Plans for the site to the rear of 28 Northorpe Lane, Northorpe have once again undergone further changes in an attempt to make them acceptable to the Council Planning Officers. Nonetheless, I have to highlight further issues with the plans as they still stand, which if not addressed should result in a refusal of planning permission.

1. Latest site plan block layout refers

Drawing **Proposed Site Layout**

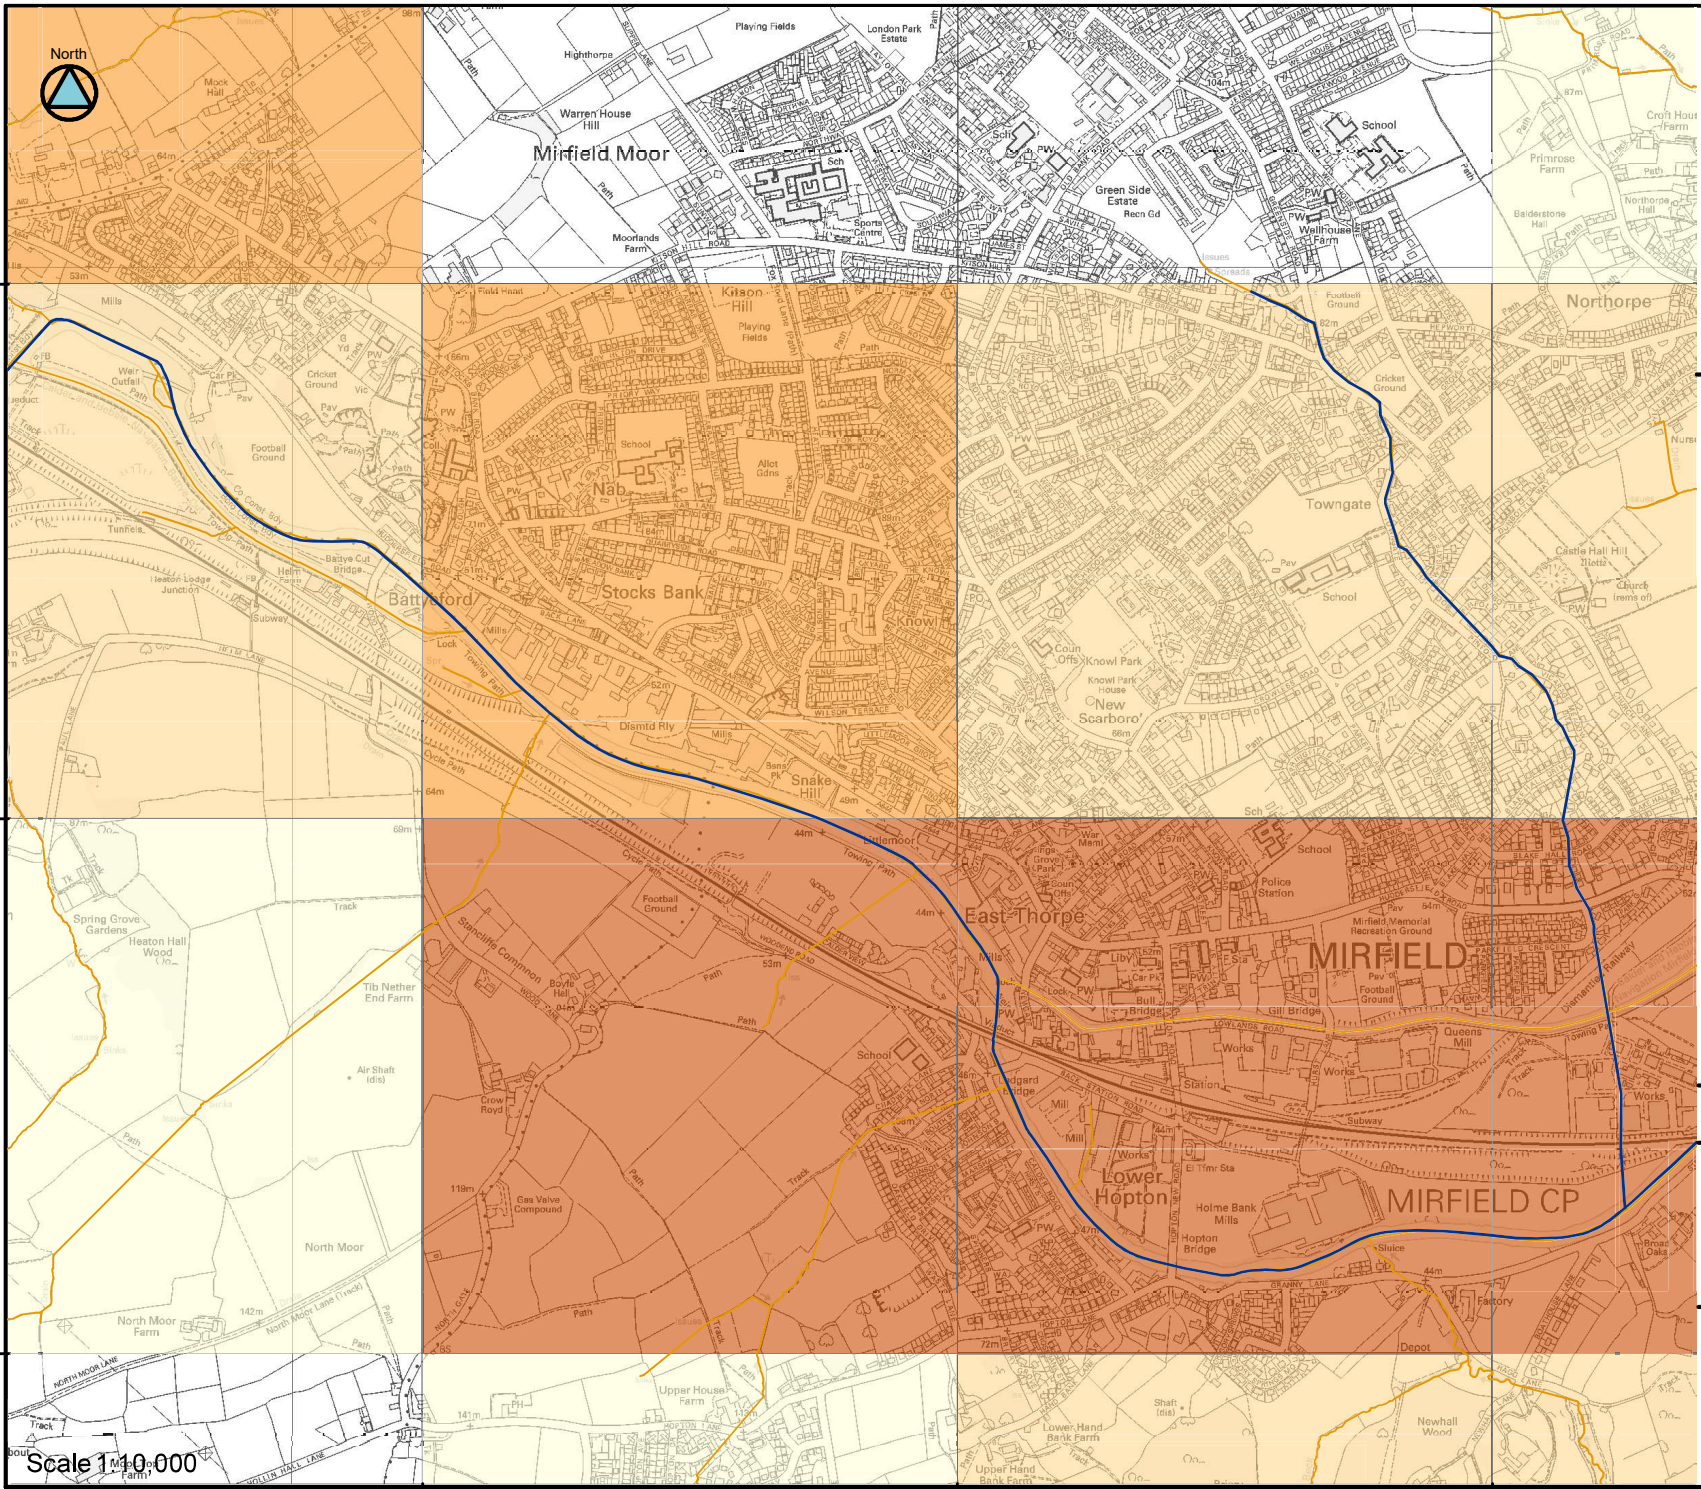
with a particular issue being the overbearing and inadequate separation between plot 11 and the existing property at 3 Northorpe Court.

Plot 11 is positioned uphill of and will look directly down into the existing property at 3 Northorpe Court in an overbearing and intrusive fashion. This design aspect in no way enhances the existing environment or is complementary to the amenity of Northorpe Village.

I therefore apply the similar stipulation that was used between plots 18 and 20 against a blow up of the Mulberry house design at plot 11 from reference 1 above, showing the separation to 3 Northorpe Court labelled as 22639 mm (= 22.6 metres). I have to make it clear that this 22.6 metre depiction in figure 1 is a mistake/misrepresentation by the architects since their labelled line is quite clearly not measured between the nearest habitable room windows. The correct datum of 3 Northorpe Court to measure the nearest habitable room window lies to the right (i.e. south) of the measurement on the latest site plan block layout drawing, and is now indicated in red on Figure 2 included below. When this nearer habitable window of 3 Northorpe Court is taken into account, the separation distance between habitable windows to plot 11 is quite clearly less than 21 metres. I have taken the measurements myself but the site architects will clearly see their error once you inform them of it.

Therefore, I have to ask that the Architects go back to the drawing board with regard to plot 11.

Correct minimum separation of at least 21 metres to be achieved **between habitable windows** across the red line highlighted. Therefore plot 11 either has to be removed or resited much further to the north.

3. Dangerous and non compliant road radius on a blind bend adjacent to plot 28.
- Once again Latest site plan block layout refers
https://www.kirklees.gov.uk/beta/planning-applications/search-for-planning-applications/downloaddocument.aspx?application_number=2021%2f91914&file_reference=934061&size=2451614 , see Figure 3

Dangerous and non compliant, tight radius, blind bend (red cross), shown in reference to open and safe sweeping bends, indicated by Green ticks.

Until there is a wholesale redesign of this blind bend marked with the red cross, this design is unsafe and it would be a mistake to allow it to continue. Great efforts have been made by the architects to achieve safe visibility arcs in response to previous feedback (see the green tick bends) BUT it would be a dereliction of obligation not to address the glaring danger to safety indicated by the red cross. The current approach is obviously inconsistent; two open bends with good visibility but one dangerous blind bend is not acceptable. Who would want to encounter the refuse lorry or Yorkshire Water Pumping station lorry coming around a blind bend with no warning?
